A46 Active Travel Partnership Comments

7.4 Transport Assessment table 11

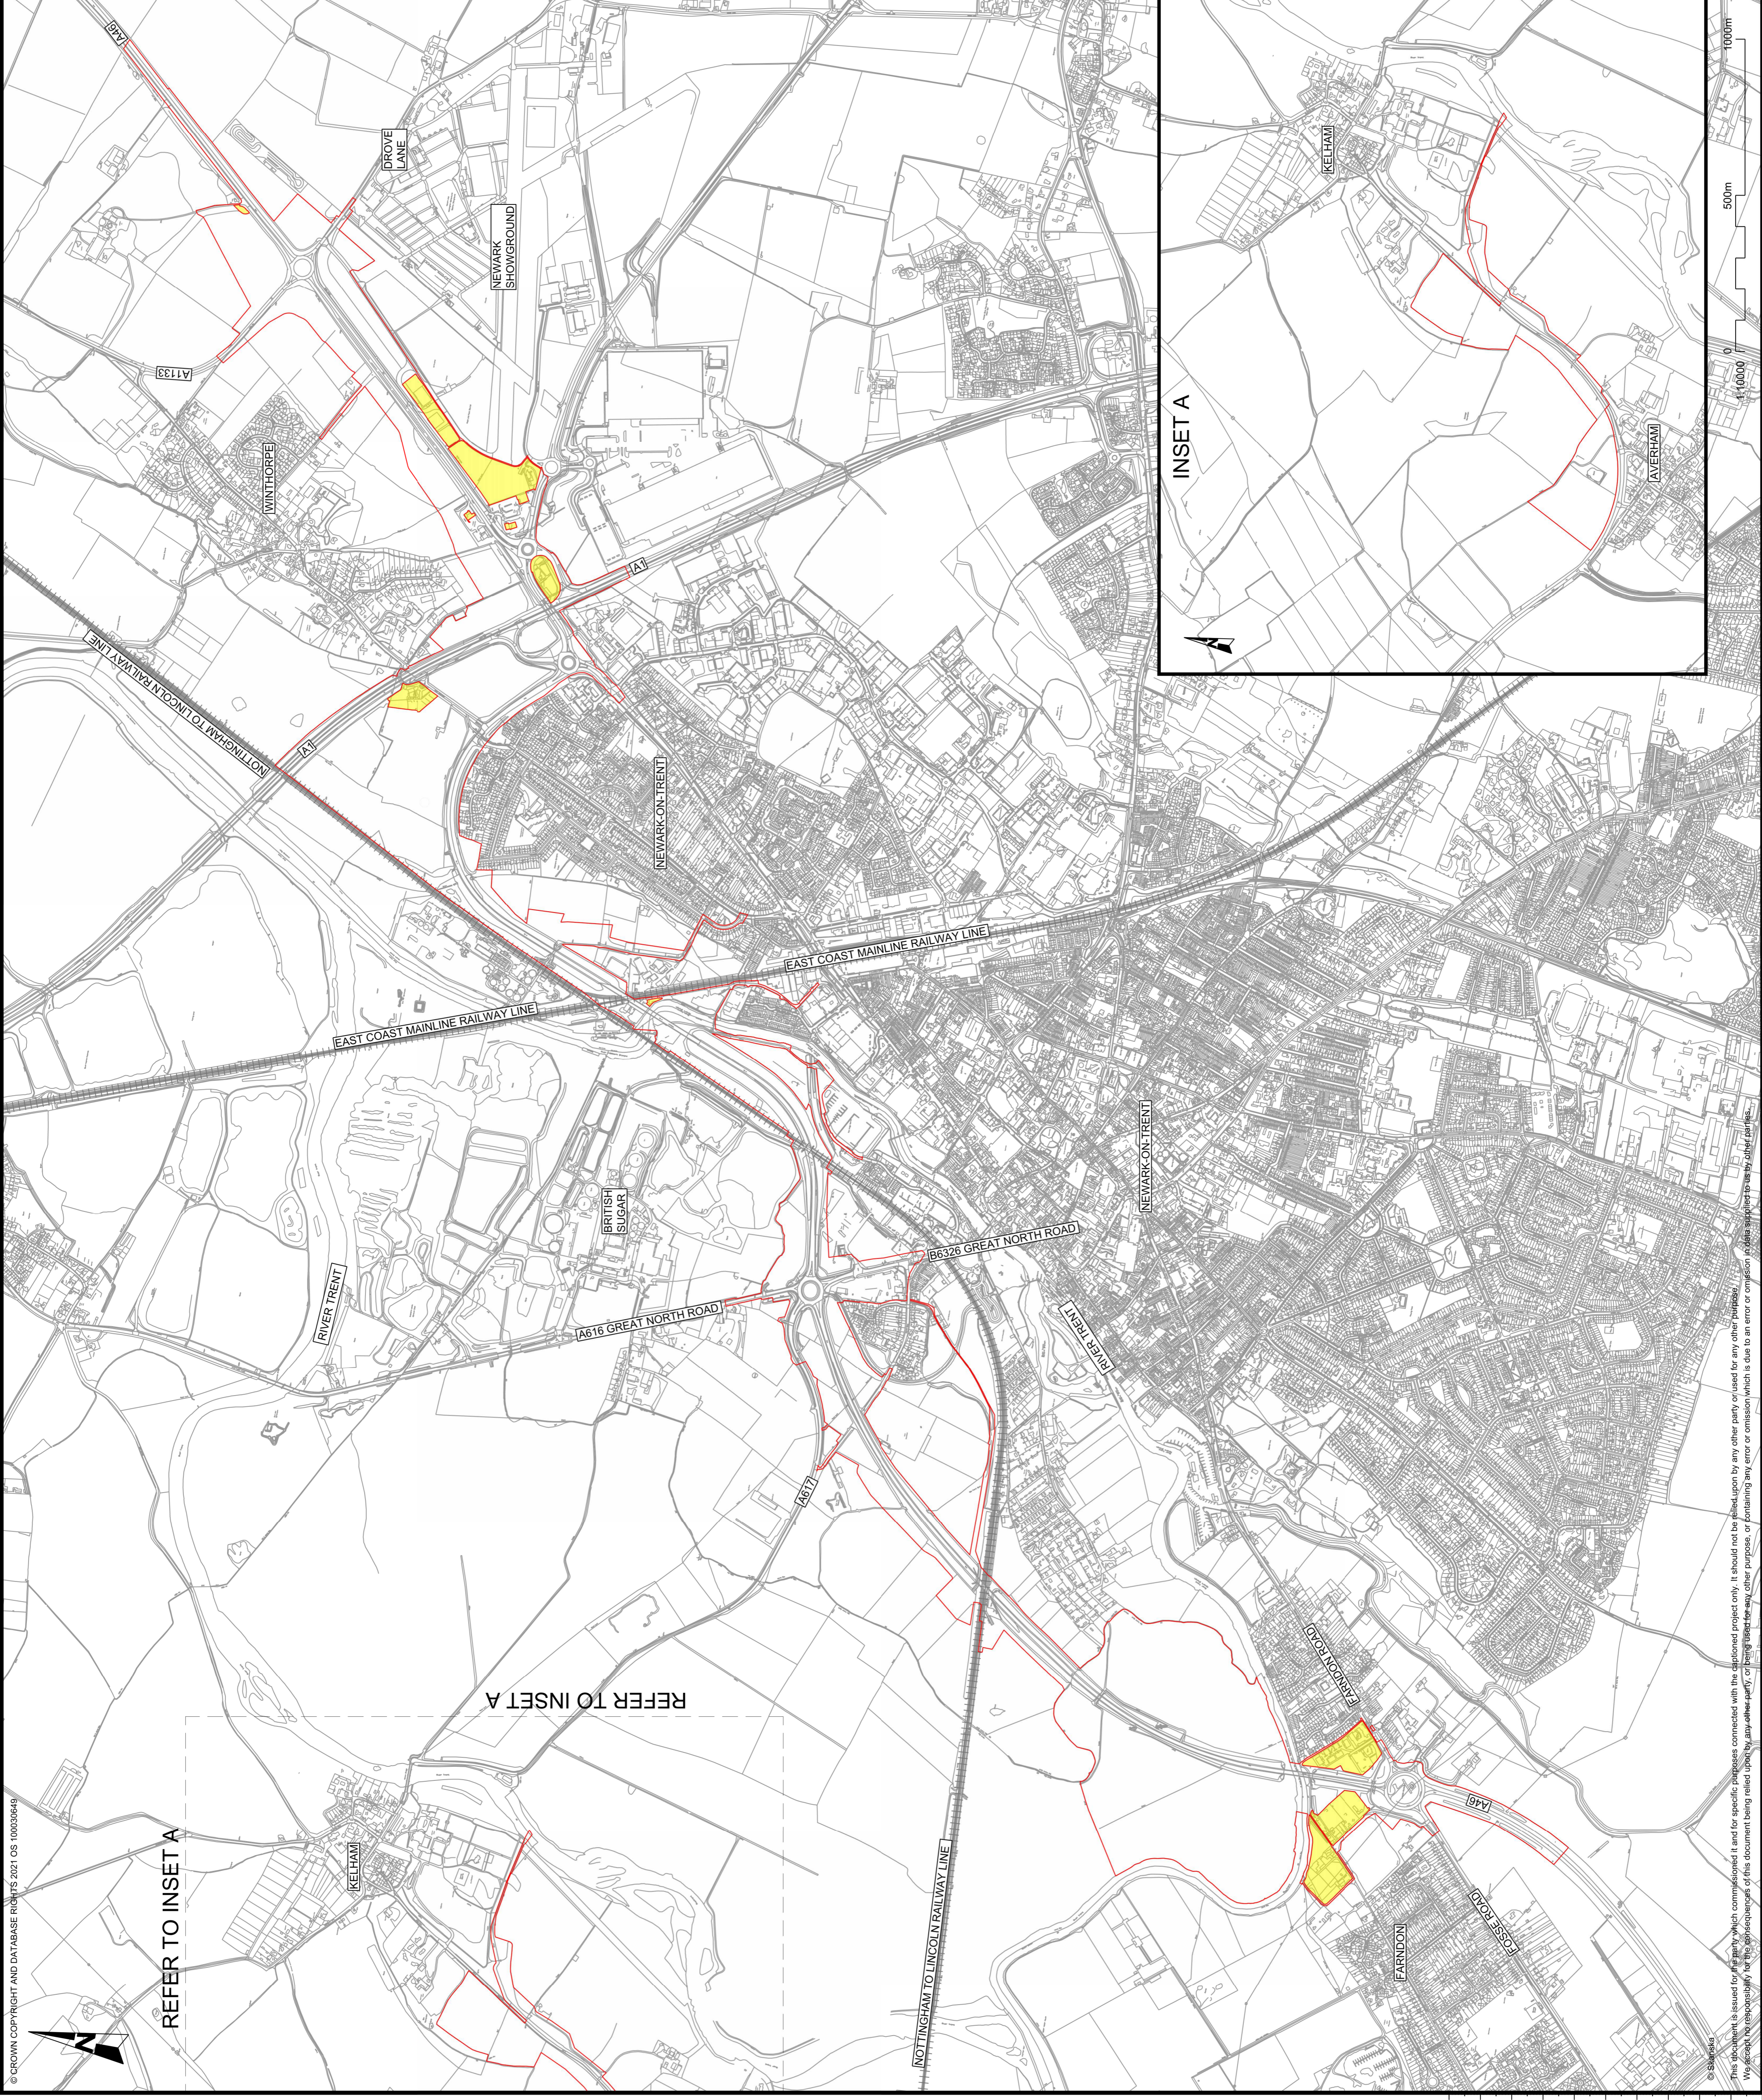
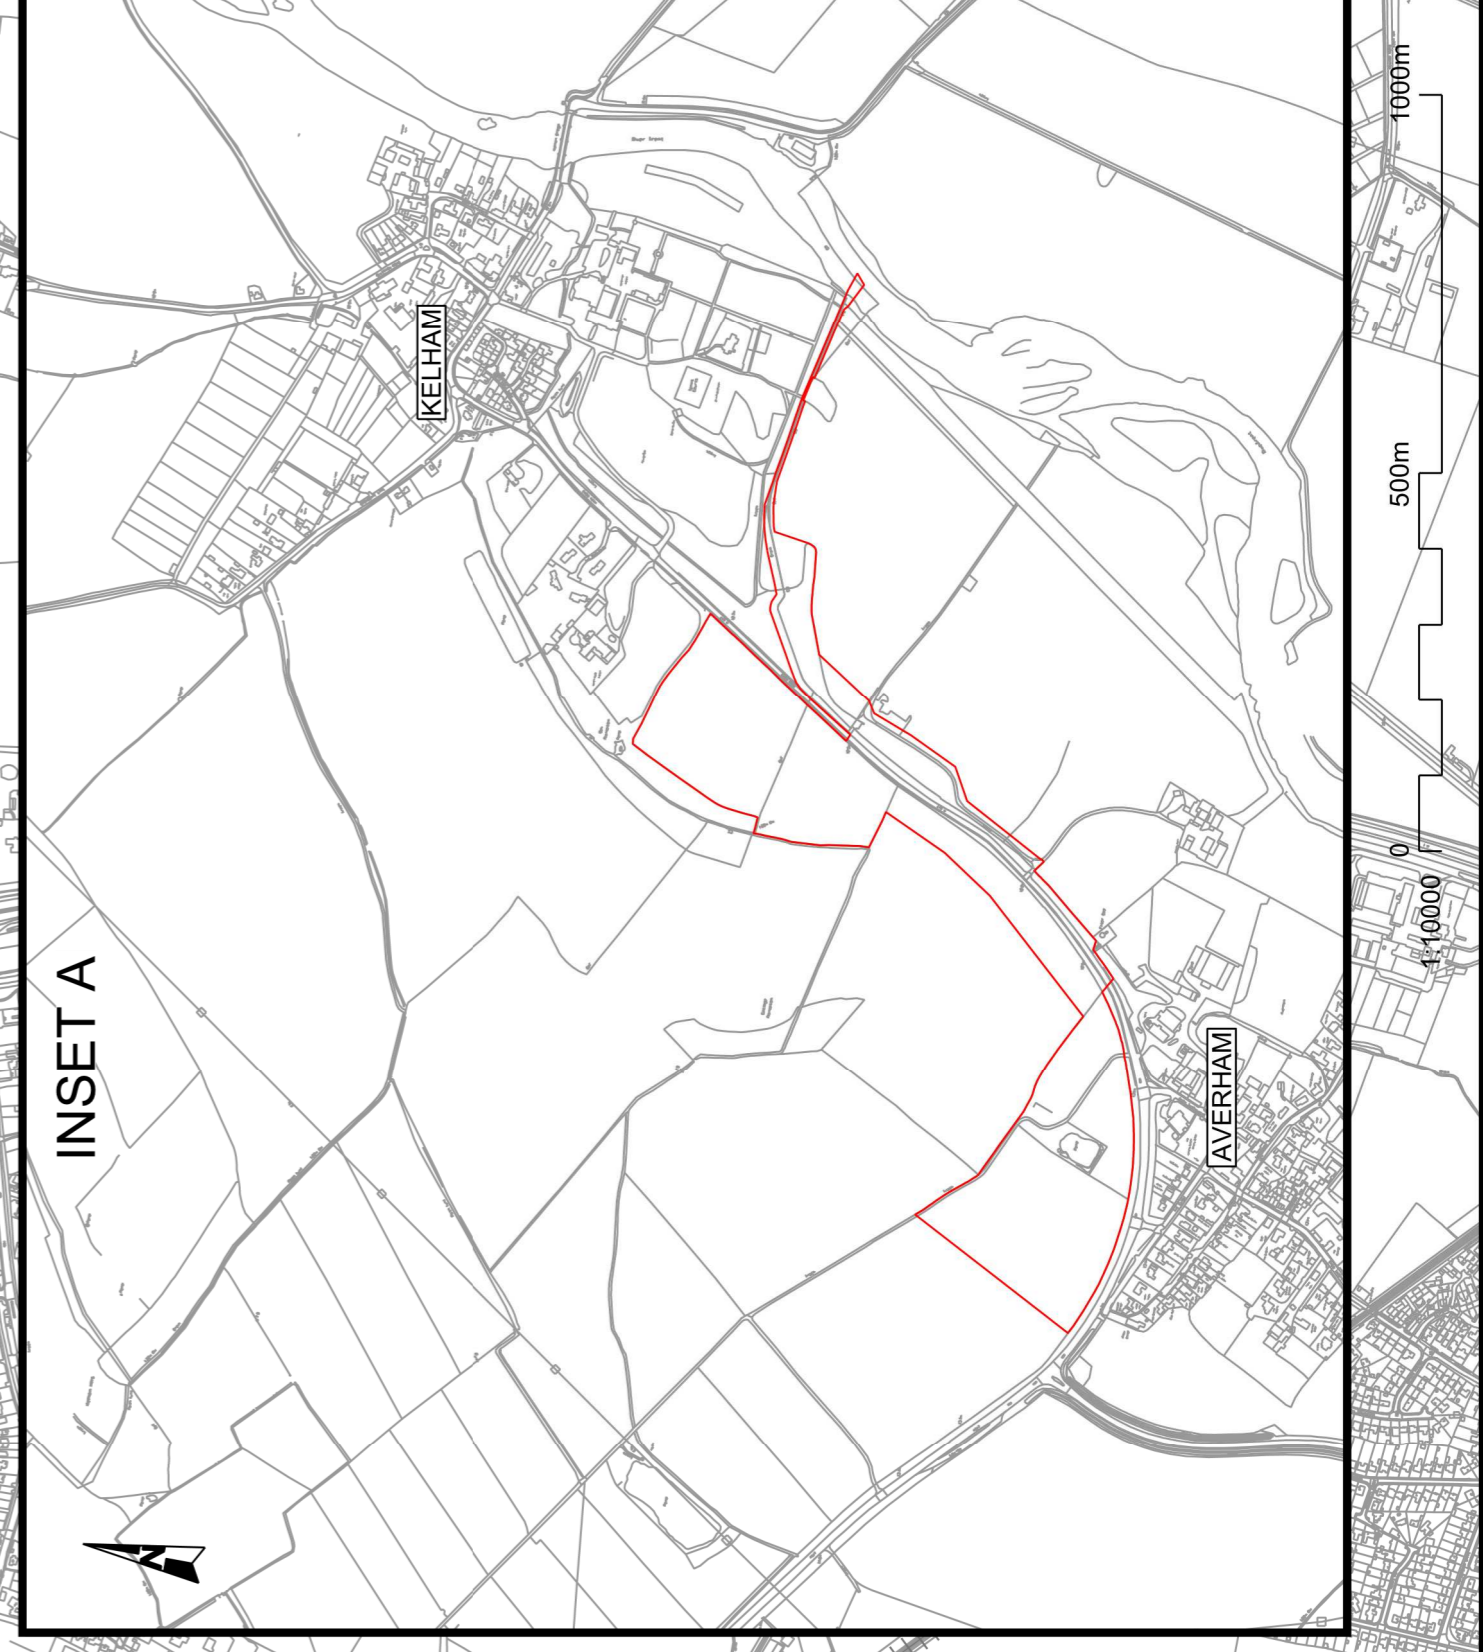
1. Our concern is with the eastern end of the scheme where NMU have to negotiate ever increasing traffic volumes and complexity through the A1, A46 & A17 junction system that severely impedes NMU. Travel needs of NMU are as important as motorists' and their transport needs should be given due regard. That means at the very least that the Active Travel network will not be degraded and that journey times and distances should not be increased without mitigation. Environmentally in this context mitigation has three meanings - *Avoidance, Minimisation and Compensatory Mitigation*. Our objection focusses on the latter. In providing compensatory mitigation for the flood plain and bio-diversity areas of land were included in the Order Limit(OL). NMU have not been treated in the same way.

The design team have admitted extending Newark BW6 (alongside the Trent) across Winthorpe Rack field would be a compensatory mitigation for the Winthorpe Road link. Discussions with the landowners have convinced us that they would not willingly dedicate the missing section. This means applying for designated funding is misdirected. Changing the OL and sorting this out should be made a condition of consent so a solution can be reached.

Whilst this route is further from the OL it would create another access point to guide NMU away from the roundabout complex. It is already in use but Statutory Declarations starting in the 1980s block a right of way claim. The route would reduce the NMU pressure on the main junctions as it could use the existing bridges under the A1 and over the A17. Rejected as outside OL.
